**Planning Department  
Transportation Development Services**

**Re: TLC Pet and Uptown Cat Hospitals, 1300 Wyoming Boulevard, N.E.  
Traffic Circulation Layout**  
Engineer's/Architect's Stamp dated 10-24-14 (J20-D027)

**Re: TLC Pet and Uptown Cat Hospitals  
1300 Wyoming Boulevard, N.E.  
Request for Traffic Circulation Layout (TCL) for Building Permit Approval**

2 H.C. Ramp Detail
Scale: Not To Scale (Isometric)

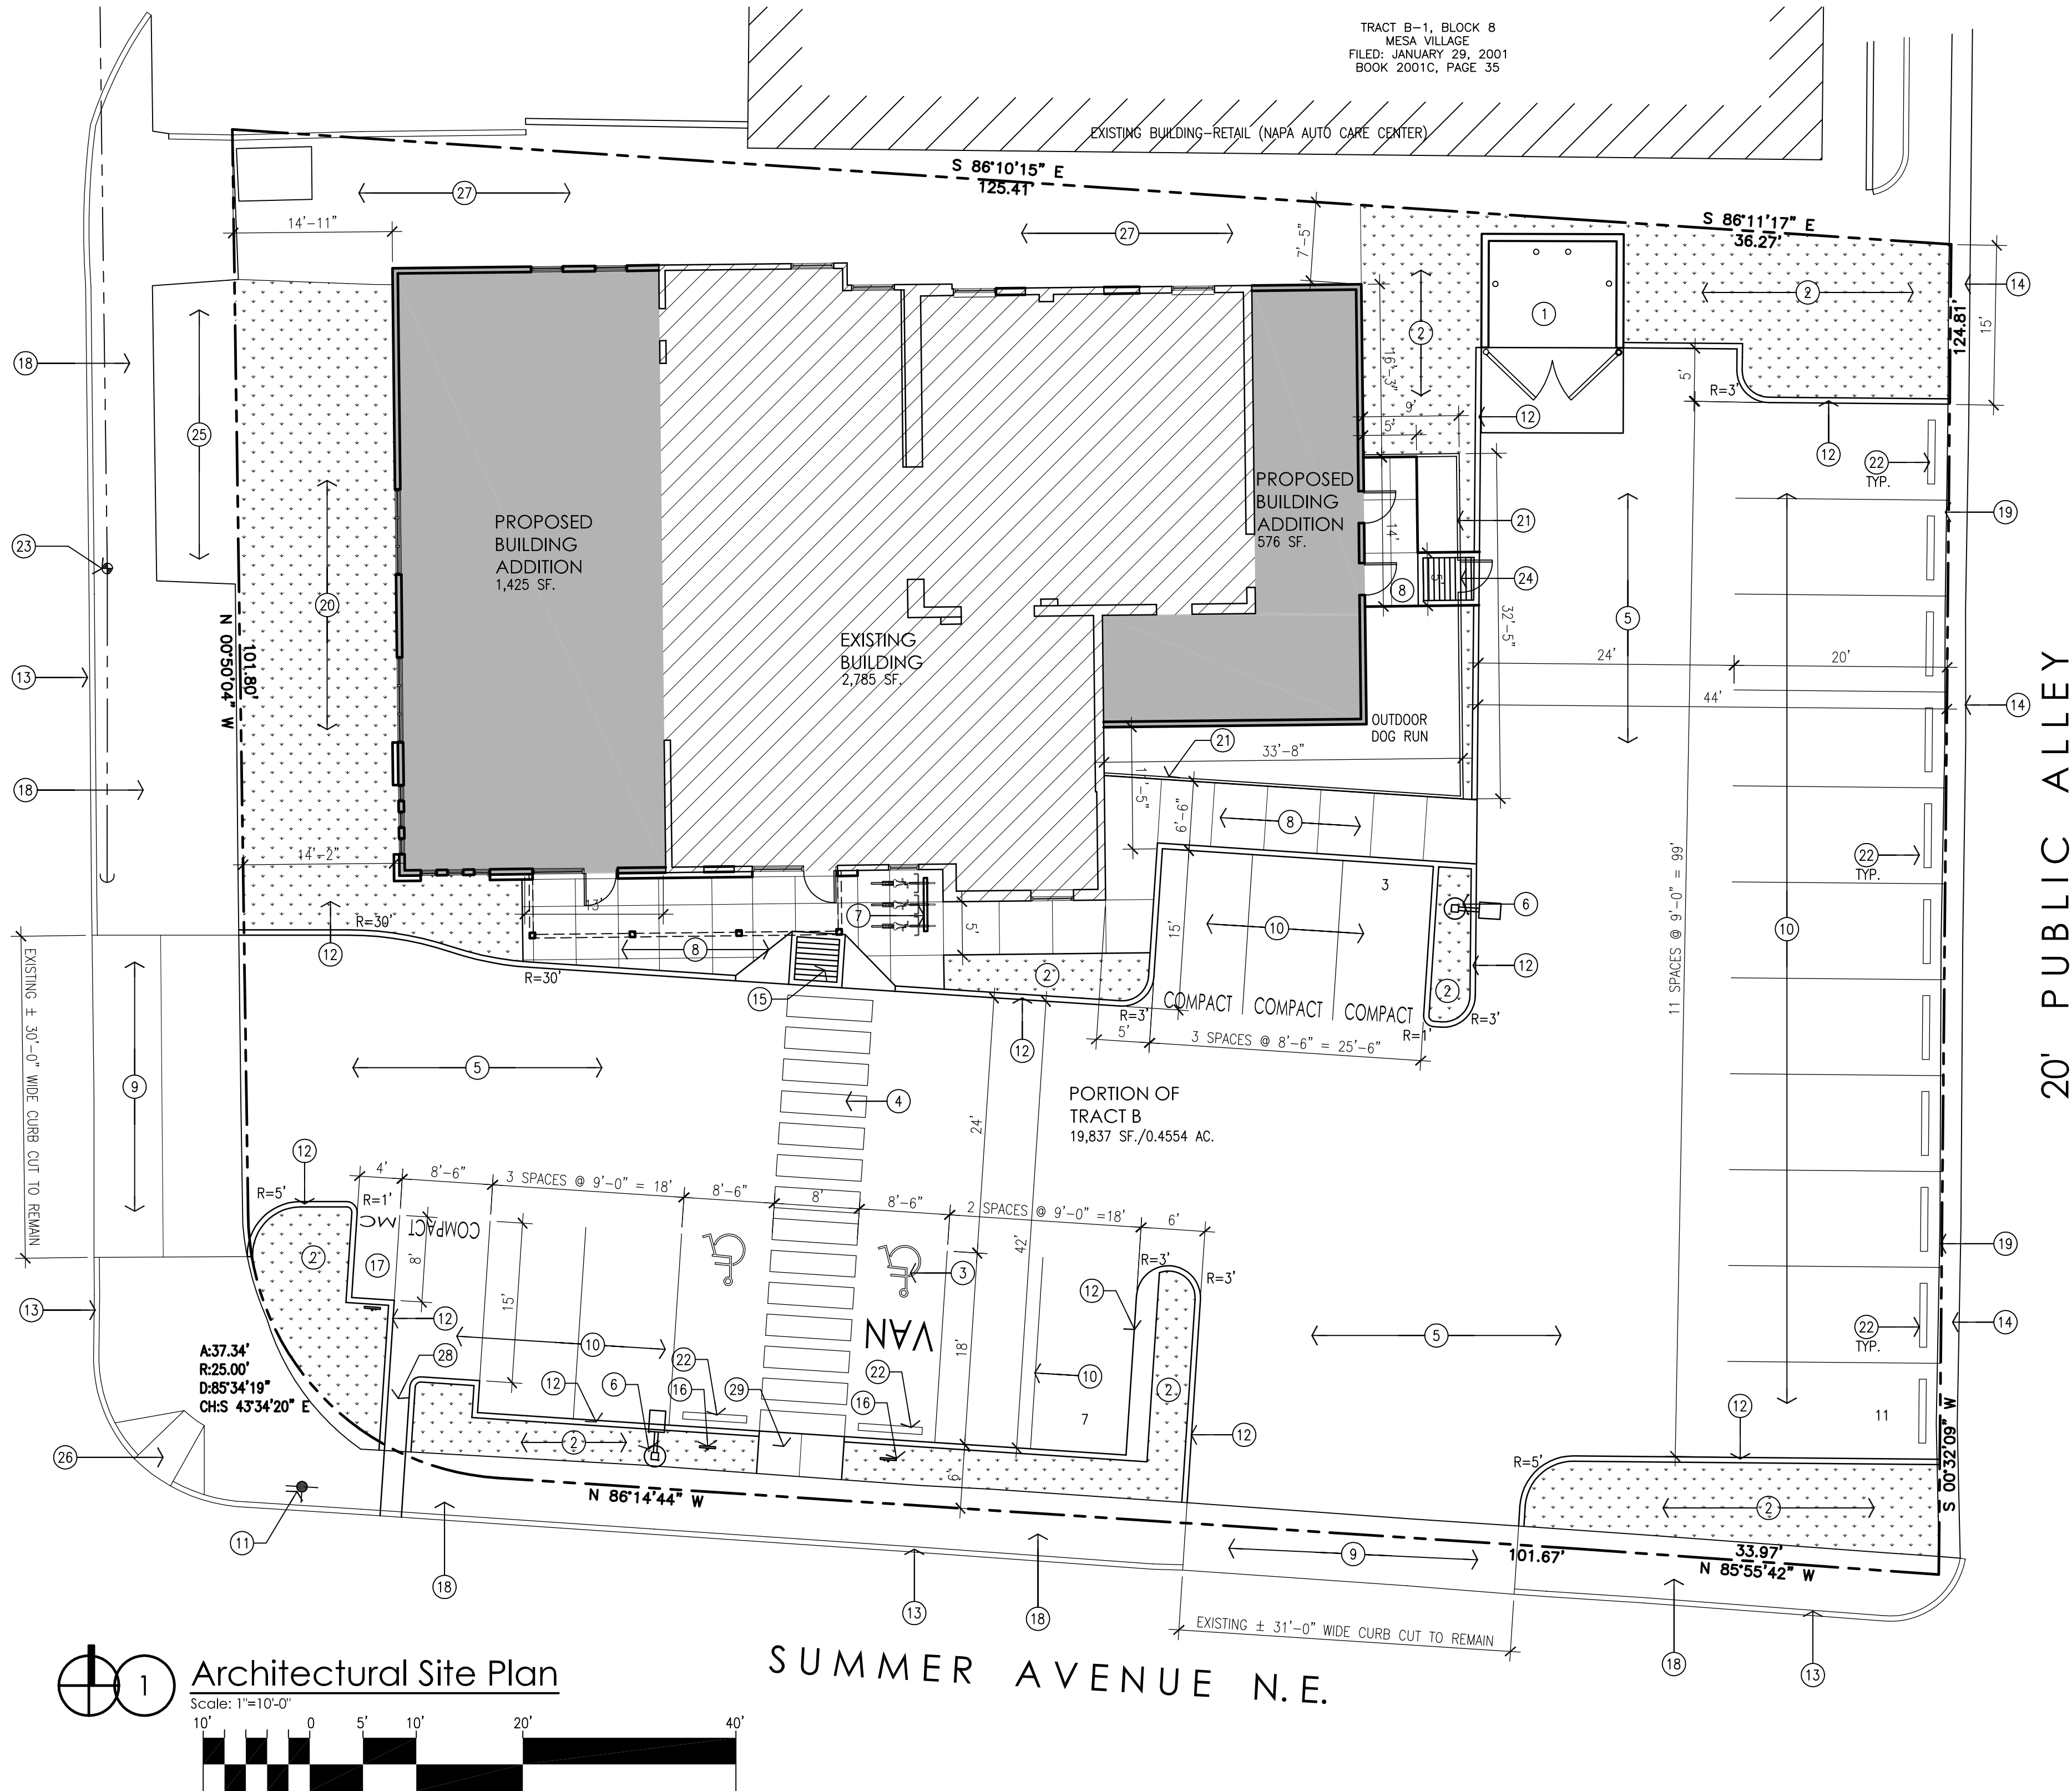
9. Graphically, it appears that it will be difficult to incorporate a 6-foot wide flat ADA-accessible path in front of the door in addition to a ramp with a 12:1 slope. (Make sure that both the 12:1 ramp and a 6-foot pathway can be incorporated. The ramp is only drawn at a 5-foot length).  
*The drive aisle along the south side of the building has been reduced to 22', since parking only occurs on one side of the drive aisle, to allow for a greater sidewalk against the building, which also allows for 6' from the top of the HC ramp to the building. Additionally, the ramp detail indicates a 1:12 slope.*
